Department of Planning & Environment
LOCKED BAG 5022
PARRAMATTA NSW 2124
Attn : Rose-Anne Hawkeswood

APPLICATION	DE-2021/188
Date	18 January 2022

Development	Eastern Gas Pipeline - Mod 2 - Transfer of Pipeline Segment - SSI-9973-Mod 2
Location	Lot 1 Springhill Road, SPRING HILL NSW 2500

**FIGURE B-3**

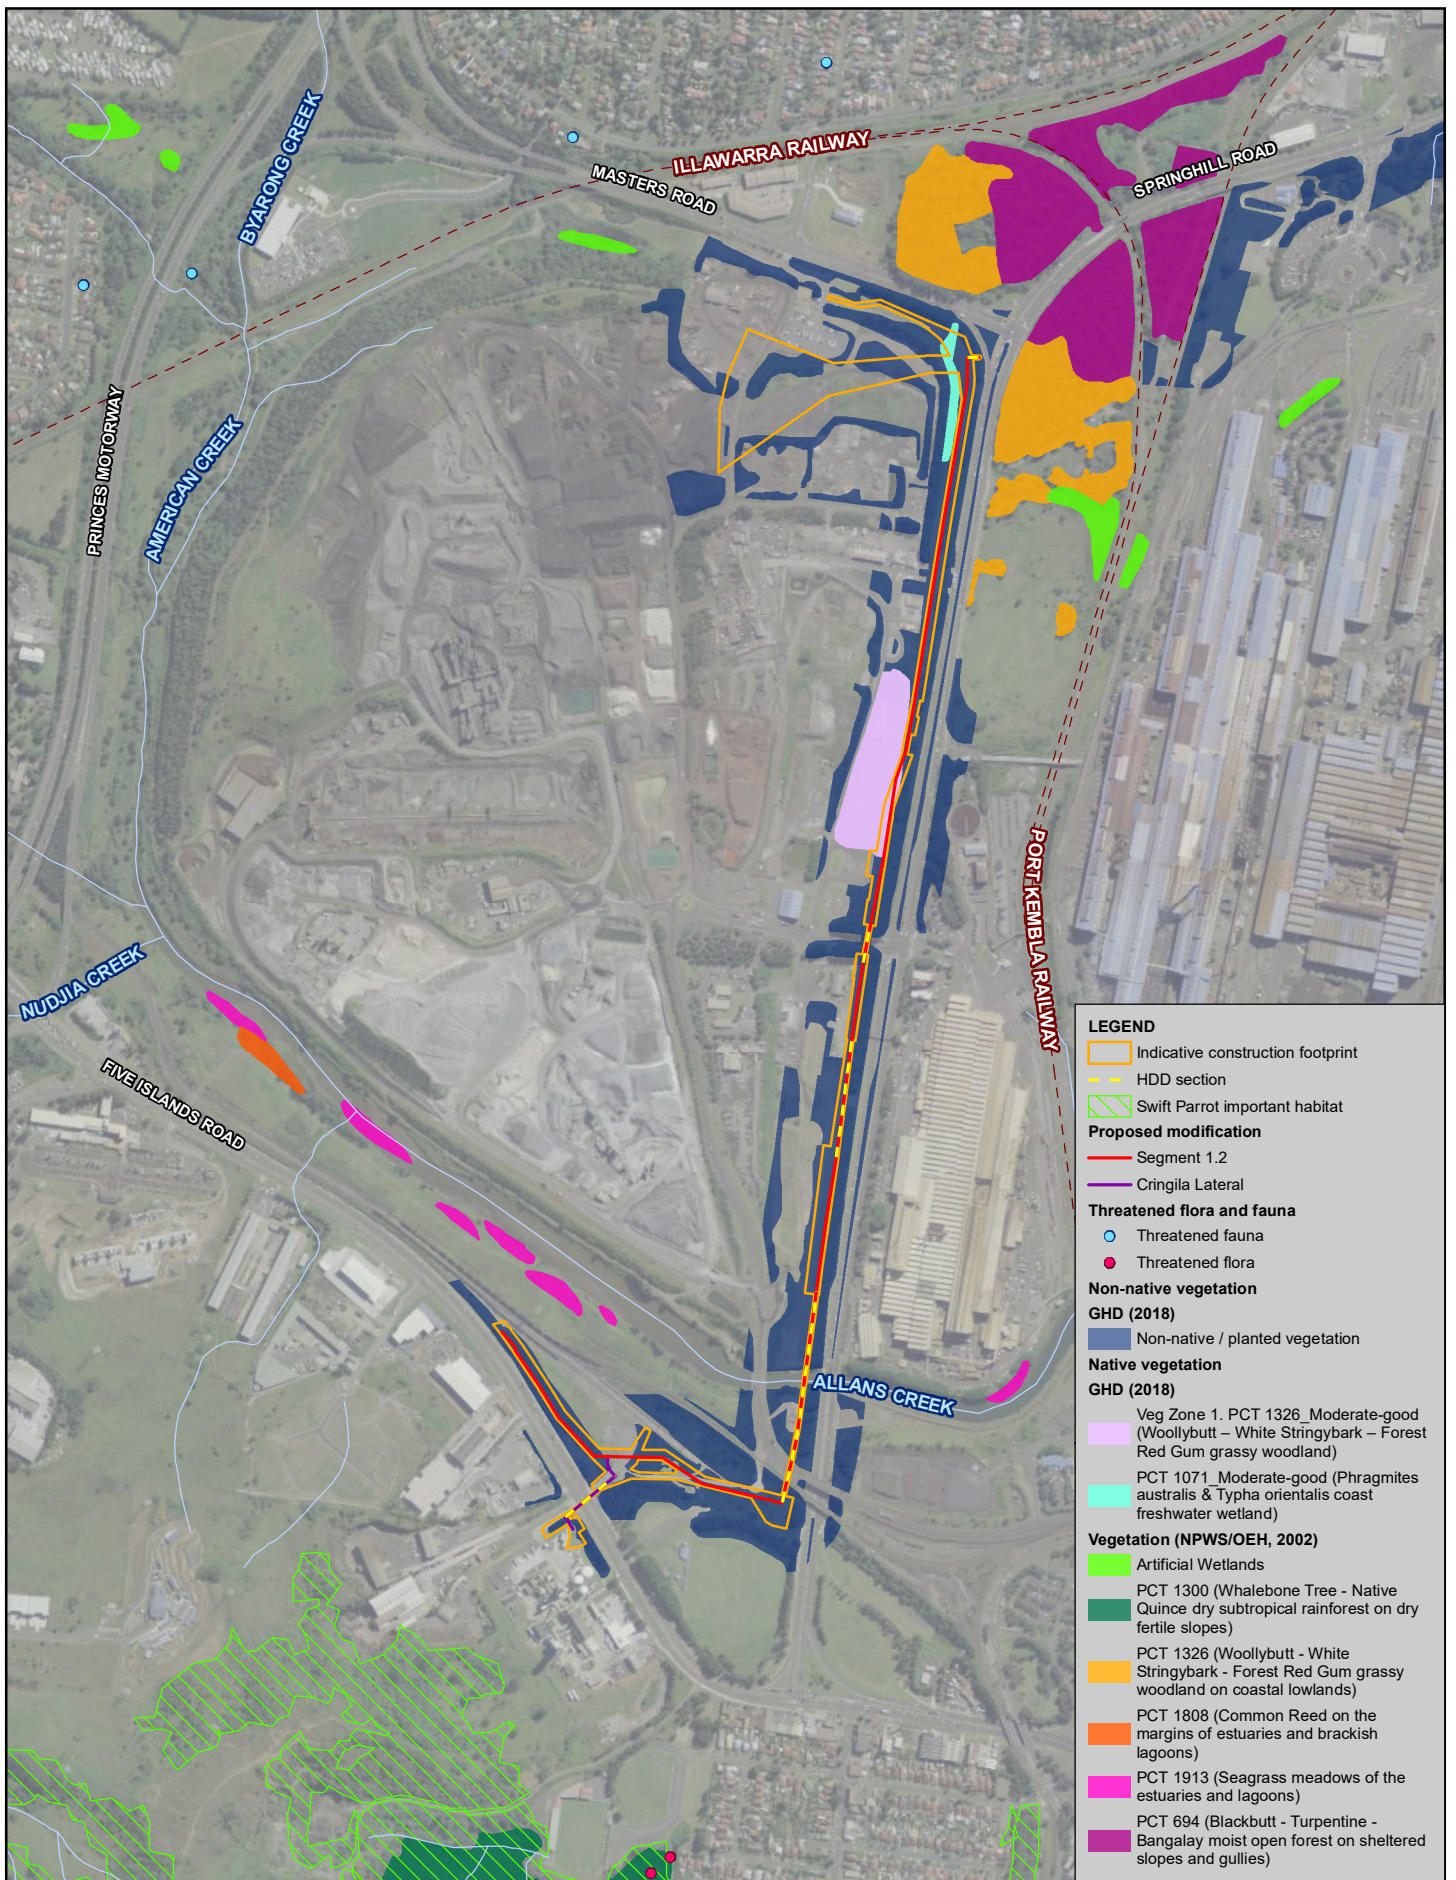
The route comes within close proximity to the listed archaeological site for the former Berkeley House (#6519) which it is noted and mapped as an irregular dot rather than being based on previous archaeological investigations.

The Modification Report notes that a 2018 GHD Heritage Report was prepared that considers historic archaeological potential under the NSW Heritage Act 1977 as per the SEARs recommendations. It is noted this report has not been provided with the modification and Council's Heritage staff are unable to locate it on the previous file.

An updated Heritage Report has been provided (Appendix B) to support the modification that notes there will be no additional heritage or historic archaeological impacts.

1. GHD 2018 Heritage Report be provided to Council;
2. The advice of the Heritage NSW should be sought in relation to the use of Due Diligence for the construction of the pipelines and updated Heritage Report in regard to the modified proposal;
3. Comments from Heritage NSW should be sought on potential non-Aboriginal archaeology and the updated Heritage Report;
4. The application should be notified (if it was not already) to the Local Aboriginal Community for comment and input to ensure the Cultural Significance of the area is properly considered in the assessment of the application;
5. ILALC should be consulted with by the proponent and any comments addressed in the updated Heritage Report;
6. Any comments from Heritage NSW should be provided to Council.
